Recommendation Report for Planning Permission for Works or Extension to a Dwelling

REF NO: R/96/26/HH

LOCATION: The Lodge
Worthing Road
Rustington
BN16 3PS

PROPOSAL: Replacement of 6 No. existing windows within the main dwelling with timber framed, double glazed, leaded light effect windows and replacement of 2 No. windows and 1 No. door in 1980s rear extension with slimline, leaded light effect, heritage aluminium windows and door.

Frame 2
 930 x 770 | Quantity: 2

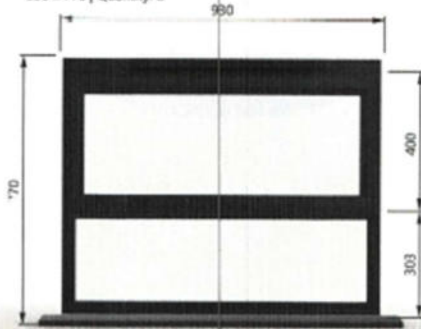
The proposed aluminium windows within the later extension are acceptable in principle as they would not affect historic fabric. However, it is unclear why the proposed designs have been chosen. For example, Window 07 could be redesigned to better reflect the character of the building, whilst the proposed door would benefit from a simpler design with less, or no, applied lead detailing.

For the later 1980s rear extension, windows 07 and 09 on the southern elevation and the door 08 on the northern elevation would be replaced with slimline heritage Crittall-effect double-glazed units. These would also include applied antique leadwork to the double-glazed units and darkened to support a heritage-style appearance.
